NORWICH TO TILBURY

EN020027

Comments on Submissions received at Deadline 1

Suffolk County Council [REDACTED]

COPYRIGHT: NOT TO BE REPRODUCED WITHOUT THE WRITTEN PERMISSION OF NATIONAL GRID ELECTRICITY TRANSMISSION Plc

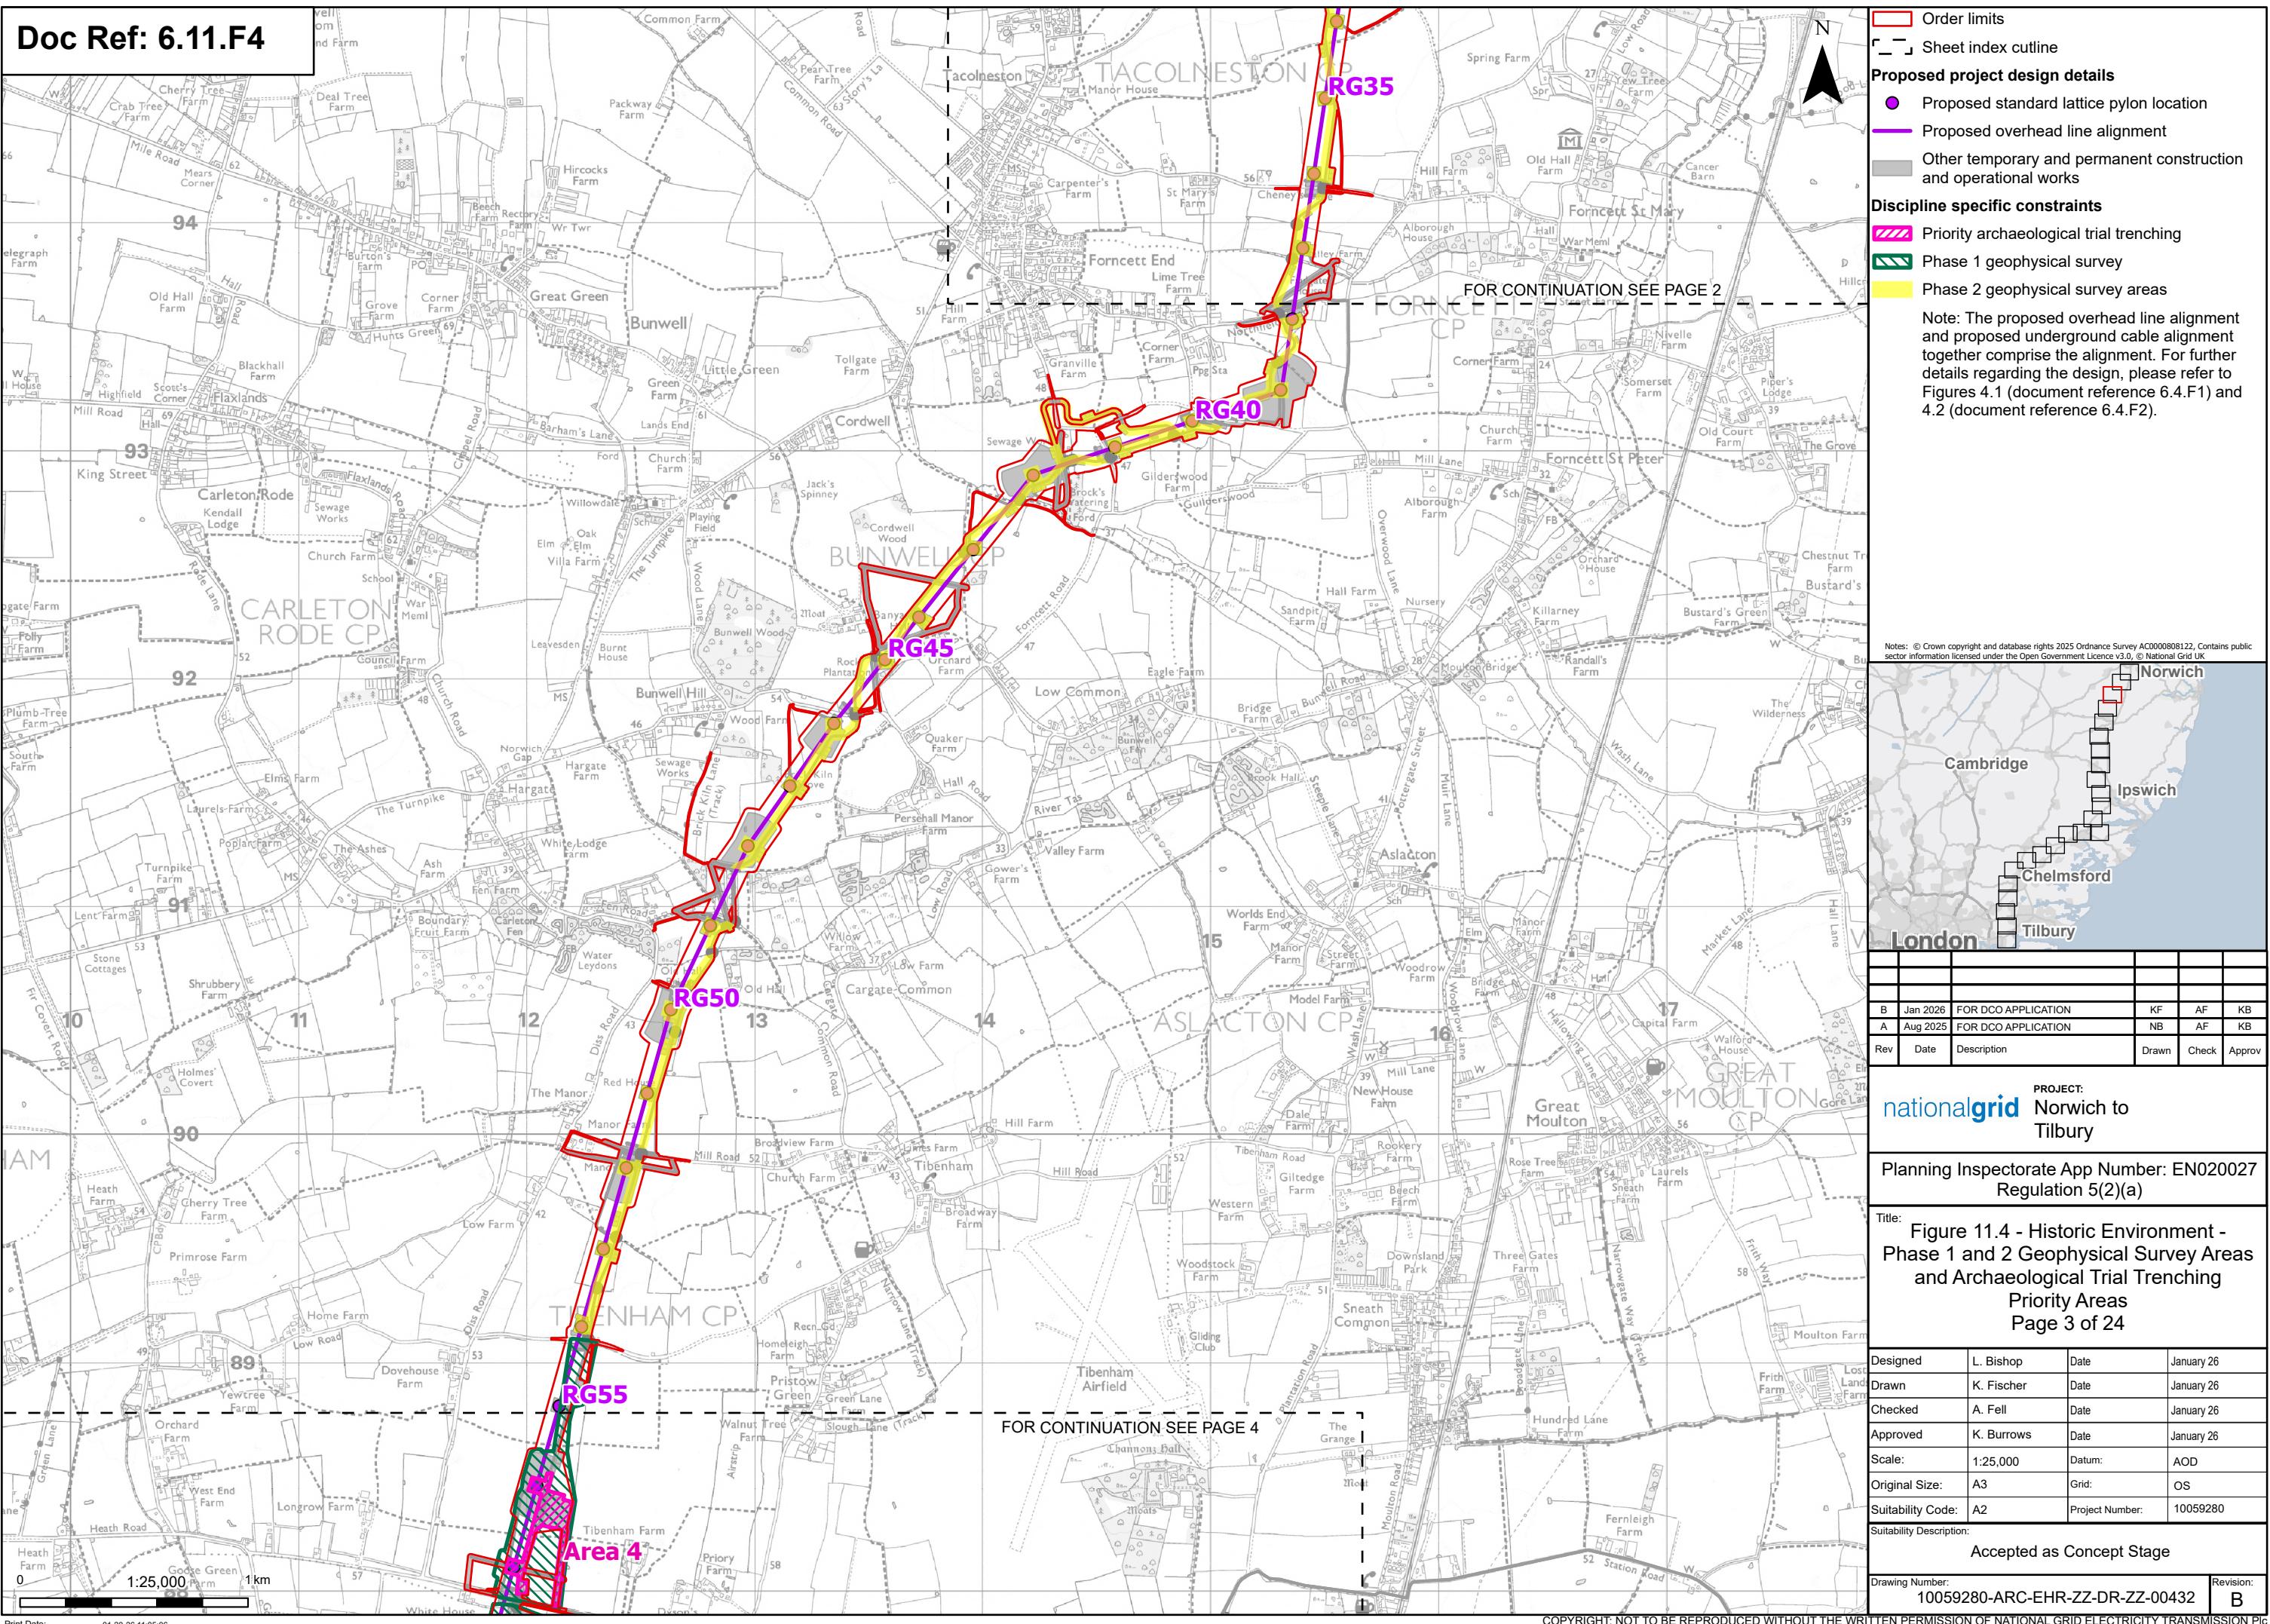
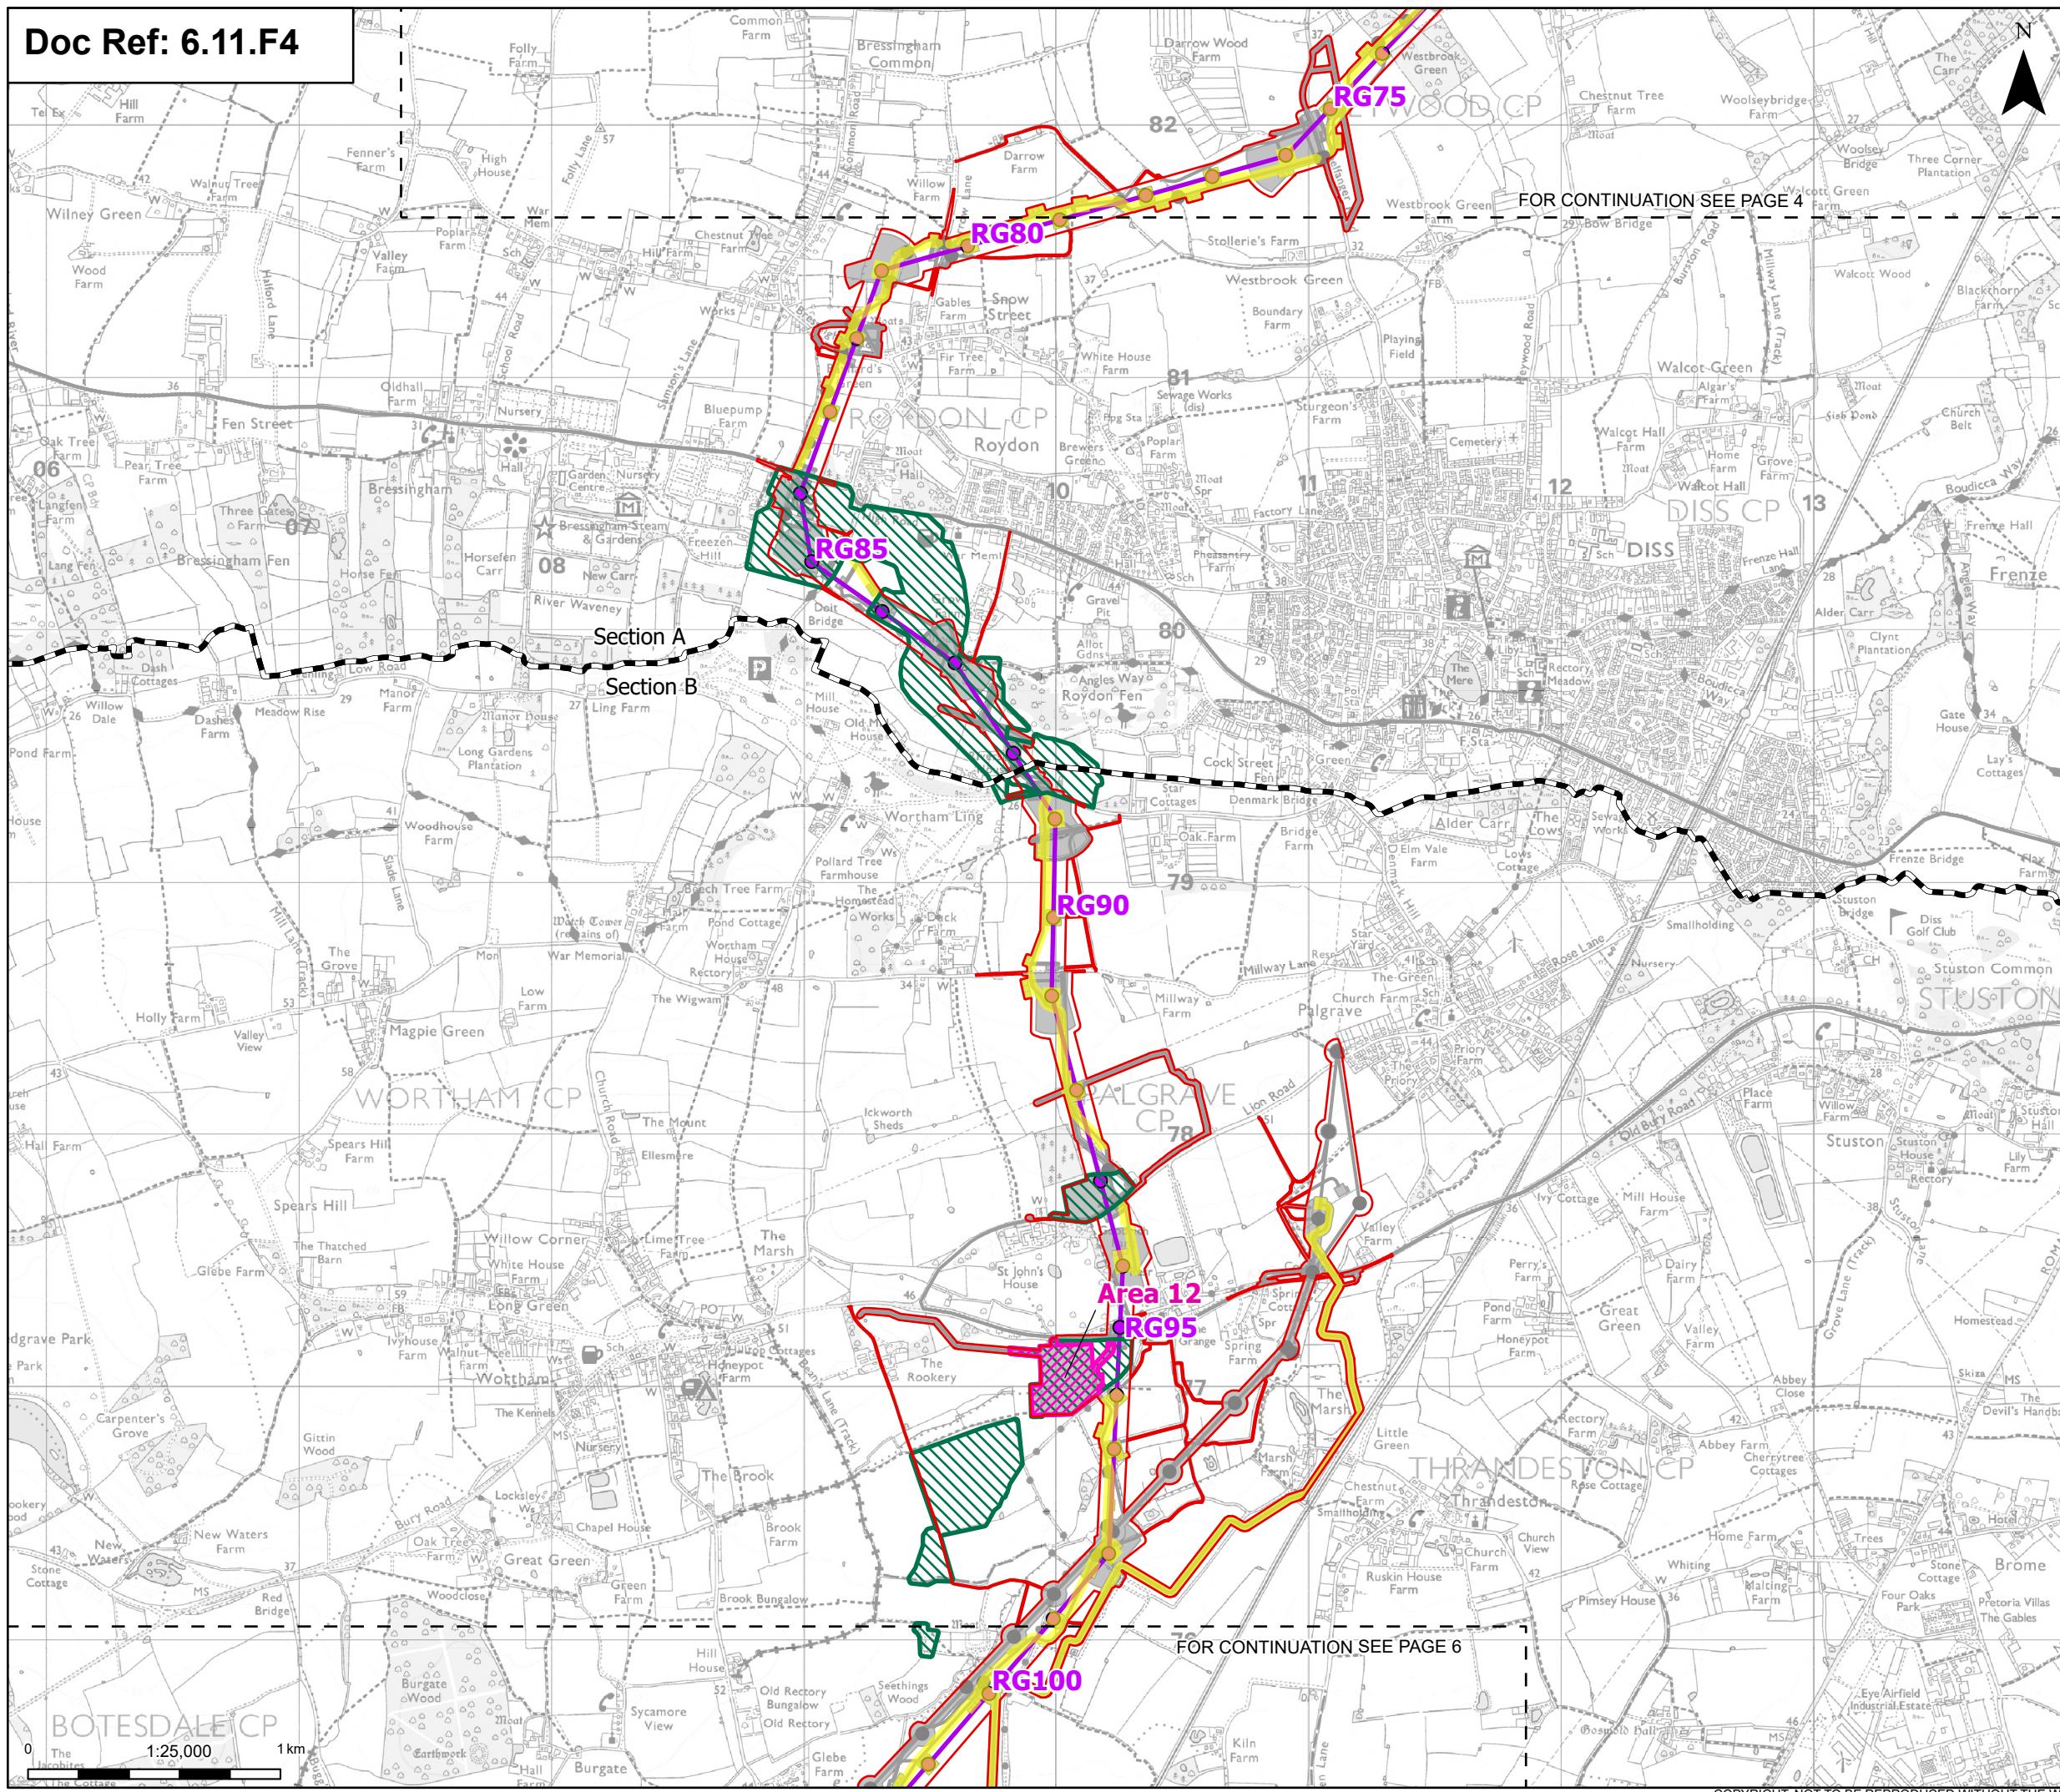
DCO requirement wording in Chapter 14 of the Joint Local Impact Report [REP1-178] .	
5.14	Historic Environment - Archaeology	<p>Table AB (24-25)</p> <p><i>“The Supplementary Environmental Information includes a Project-wide figure indicating the progress of the priority evaluation areas and Phase 2 geophysical survey (6.11.F4 Environmental Statement Figure 11.4 - Phase 1 and 2 Geophysical Survey Areas and Archaeological Trial Trenching Priority Areas [AS-082]). The Applicant proposes to update 7.5 Outline Archaeological Mitigation Strategy and Outline Written Scheme of Investigation [APP-328] during the examination phase in consultation with the Local Planning Authority Archaeological Advisors, which will include figures detailing the completed and planned evaluation.”</i></p>	<p>SCCAS notes this comment in relation to submitted figure 6.11.F4 Environmental Statement Figure 11.4 - Phase 1 and 2 Geophysical Survey Areas and Archaeological Trial Trenching Priority Areas [AS-082]</p>	[AS-082]

5.15	Historic Environment - Archaeology	<p>Table AB (26)</p> <p><i>“The Supplementary Environmental Information includes a Project-wide figure indicating the progress of the priority evaluation areas and Phase 2 geophysical survey (6.11.F4 Environmental Statement Figure 11.4 - Phase 1 and 2 Geophysical Survey Areas and Archaeological Trial Trenching</i></p>	<p>SCCAS reiterate that the Applicant must submit an amended 7.5 Outline Archaeological Mitigation Strategy and Outline Written Scheme of Investigation [APP-328] in reasonable time during the examination, incorporating LPA archaeological advisor comments. Allowing sufficient time for the LPA archaeological advisors and Historic England to comment on the document. The document must be approved by the</p>	[APP-328]

<p><i>Priority Areas [AS-082]). The Applicant proposes to update 7.5 Outline Archaeological Mitigation Strategy and Outline Written Scheme of Investigation [APP-328] during the examination phase in consultation with the Local Planning Authority Archaeological Advisors, which will include figures detailing the completed and planned evaluation.”</i></p>	<p>Local Authority Archaeological Advisors (Norfolk, Essex and Suffolk) and Historic England.</p> <p>If approval of the 7.5 Outline Archaeological Mitigation Strategy and Outline Written Scheme of Investigation [APP-328] cannot be achieved by the time of determination, the DCO must include provision for post-consent approval of the 7.5 Outline Archaeological Mitigation Strategy and Outline Written Scheme of Investigation [APP-328].</p>
